## OFFICIAL NOTICE OF DECISION

CITY OF ALBUQUERQUE  
PLANNING DEPARTMENT  
DEVELOPMENT REVIEW BOARD

**Project# 1007140**  
12DRB-70177 EXT OF MAJOR PRELIMINARY PLAT

MARK GOODWIN AND ASSOCIATES, P.A. agent(s) for JTH, LLC request(s) the above action(s) for all or a portion of Lot(s) 2A, **JUAN TABO HILLS UNIT 3B** zoned RD-SU1, located on JUAN TABO BLVD BETWEEN MONACHOS RD AND TIJERAS ARROYO containing approximately 9.54 acre(s). (M-22)

AMENDED PRELIMINARY PLAT FOR  
**JUAN TABO HILLS, UNIT 3B**  
 WITHIN  
 SECTIONS 27, AND 34  
 TOWNSHIP 10 NORTH, RANGE 4 EAST, NMPM  
 CITY OF ALBUQUERQUE  
 BERNALILLO COUNTY, NEW MEXICO  
 MARCH, 2012

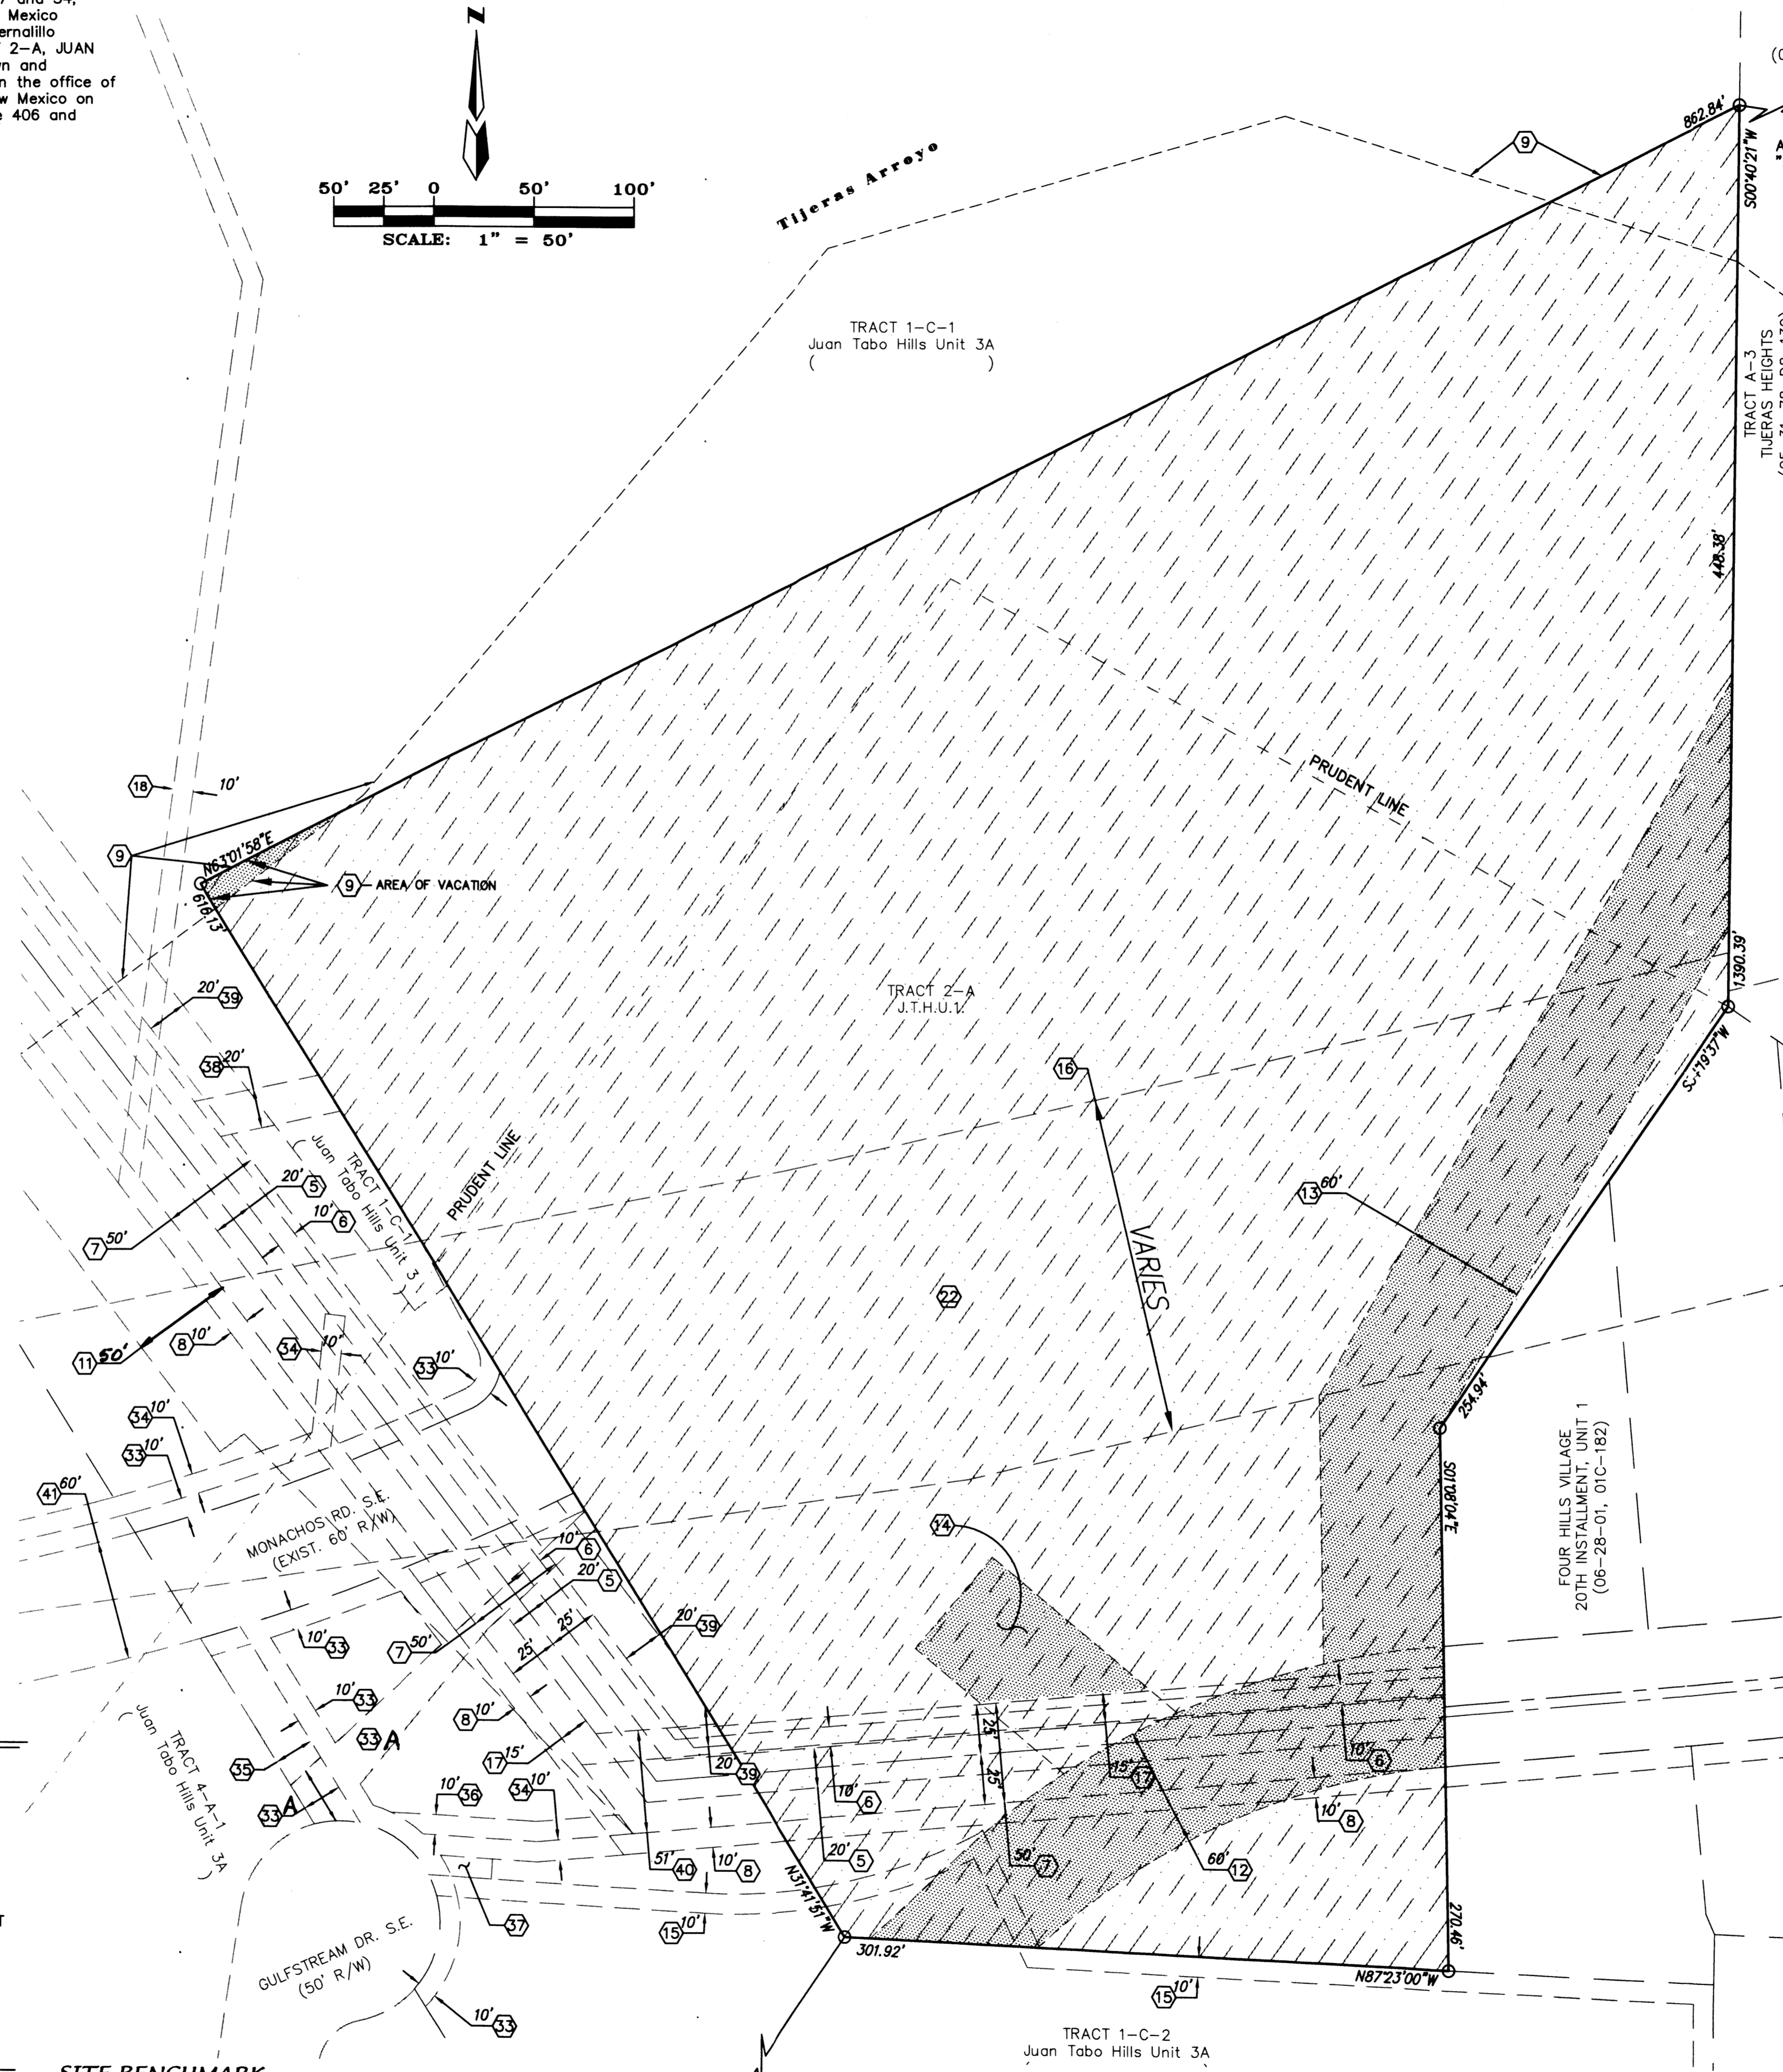
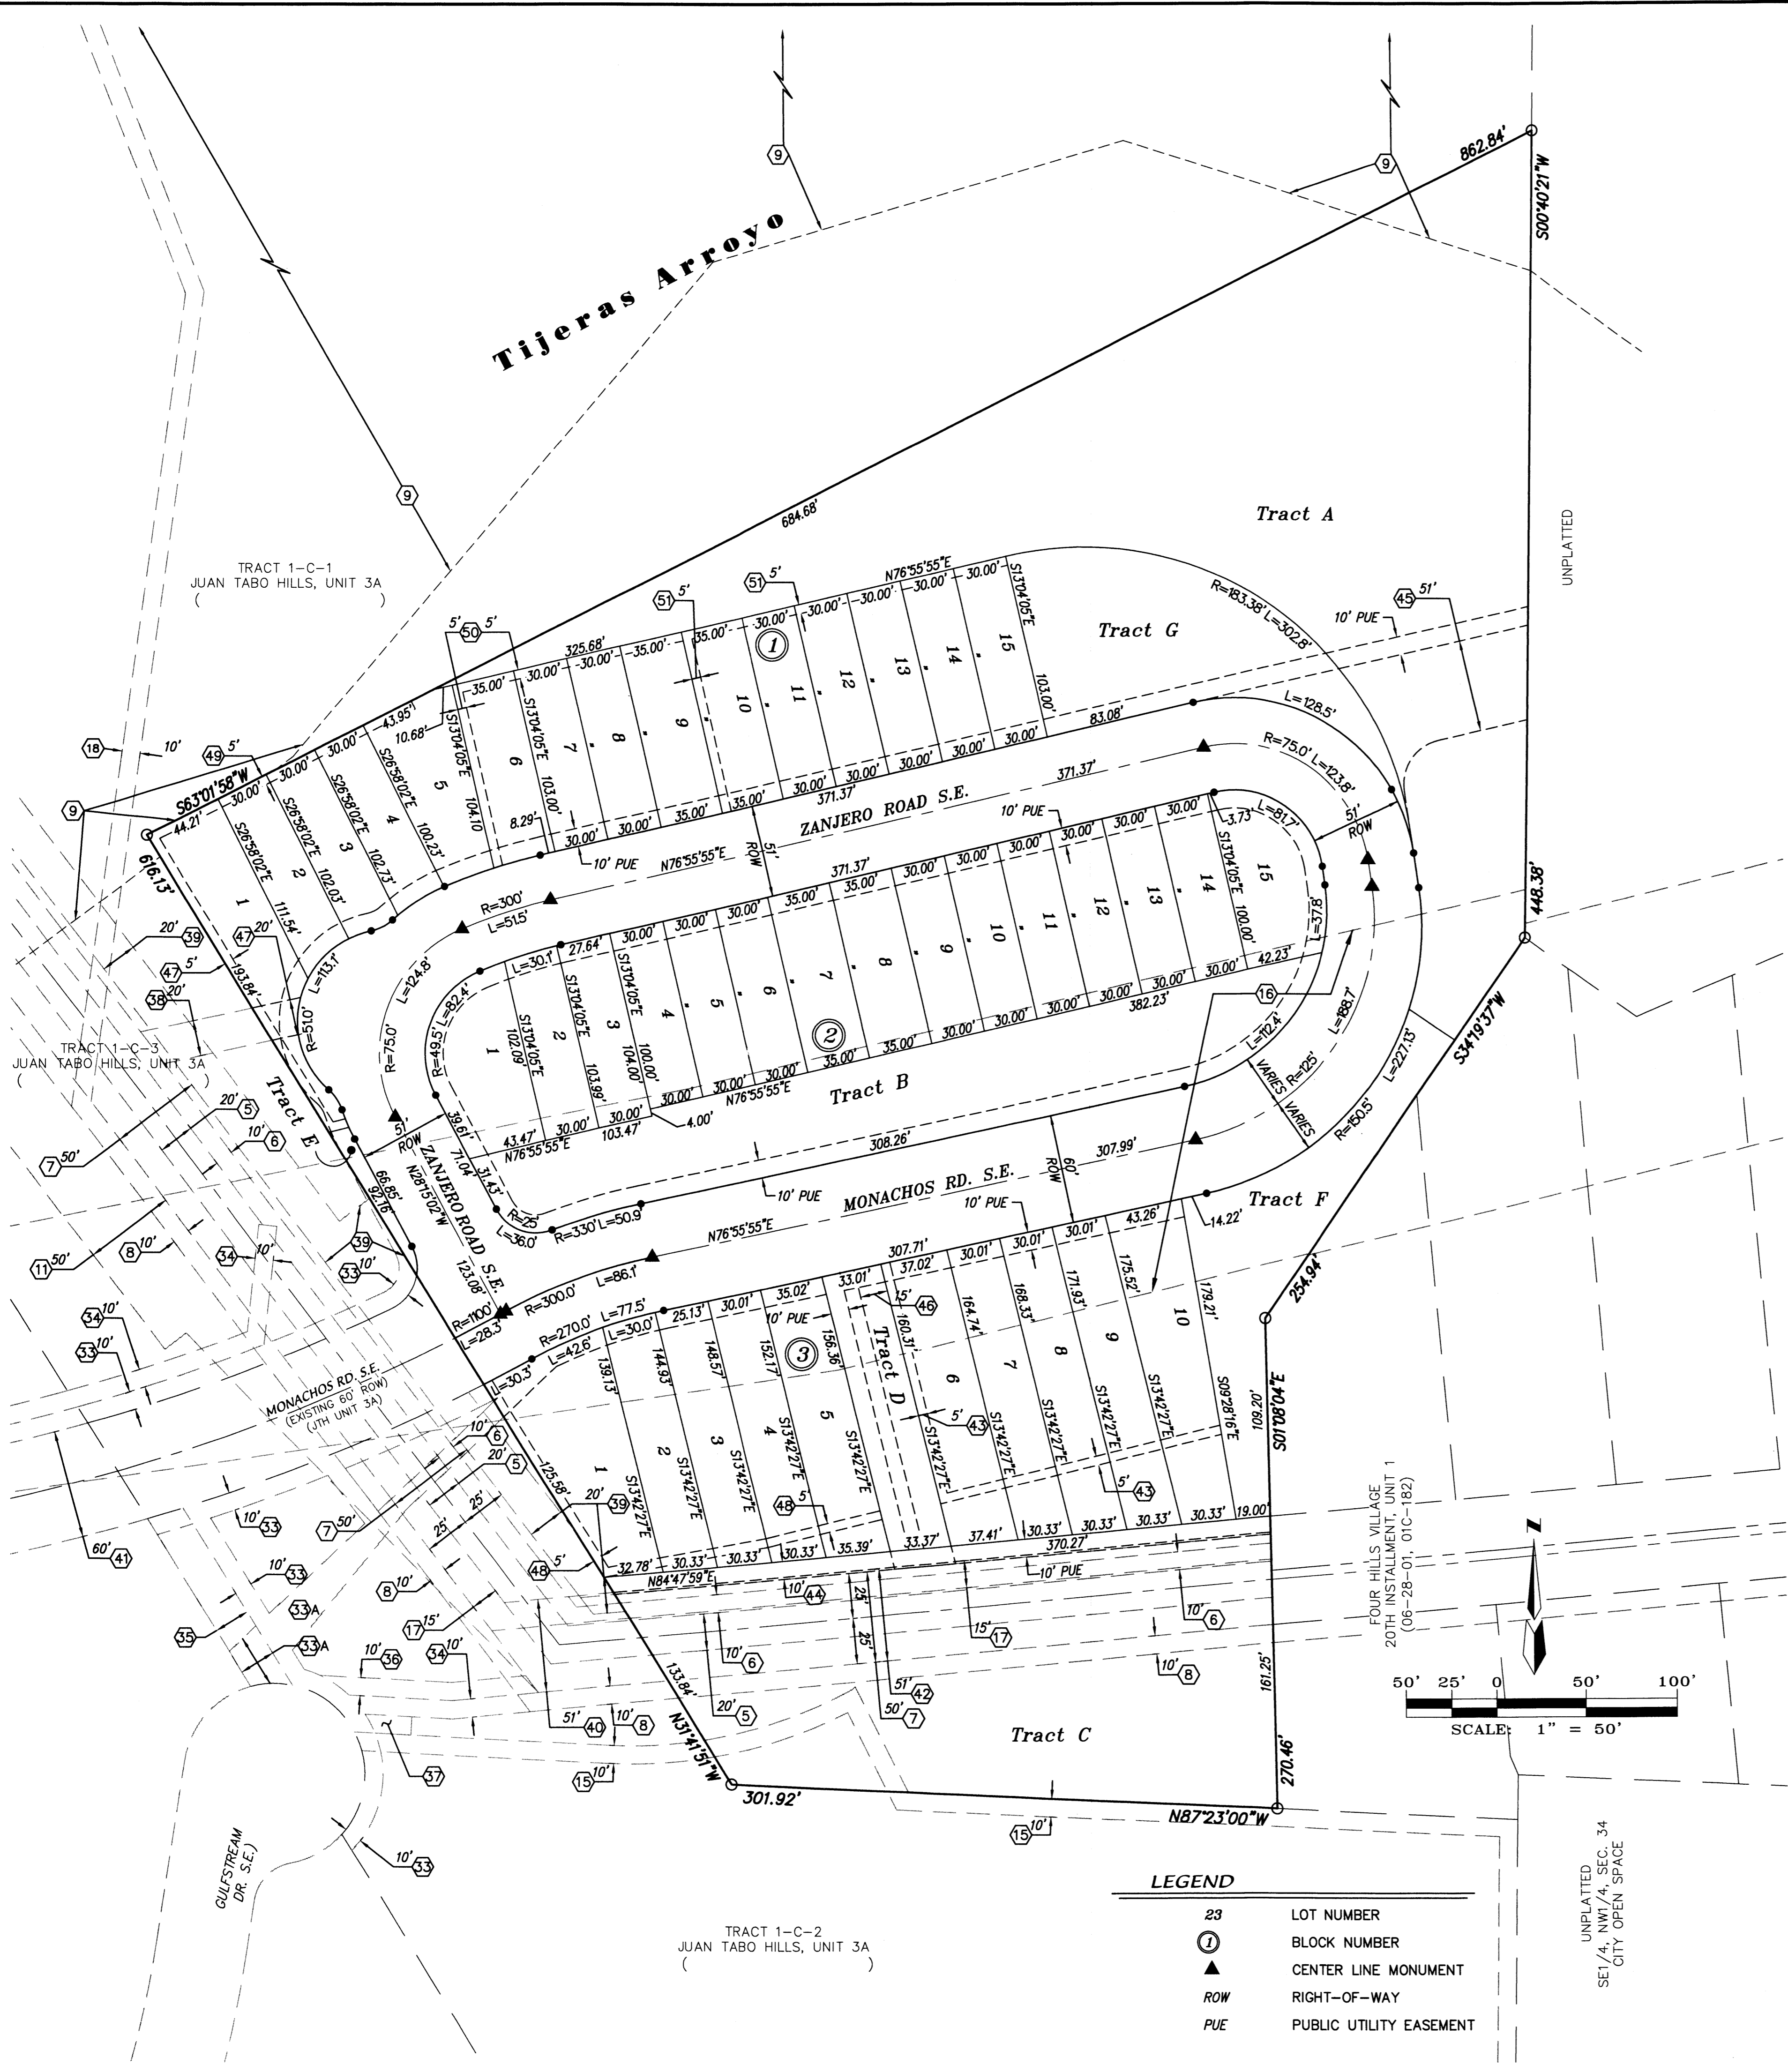
2. Certain changes in the approved Preliminary Plats have been agreed to by the parties during the review of the submitted "Amended Preliminary Plats" and those changes should be noted. For example, including but not limited to, the proposed trail alignment from the Tijeras Arroyo to provide connection to the Four Hills Village as required by EPC, the ownership of the various "open space" tracts A-E shown on the approved Preliminary Plat, and any and all agreements that the parties are able to resolve with respect to the Tract 1-C Open Space outstanding issues referred to on the documents listed above.

6. Provide a written reason for not recording a Subdivision Improvement Agreement 3 years after the original Preliminary Plat approval.
7. Keyed Note 25 notes there is a 51 foot wide Public Access Easement granted to the City of Albuquerque for Tract A which may interfere with the scour wall shown on the Grading and Drainage Plan that needs to be addressed.
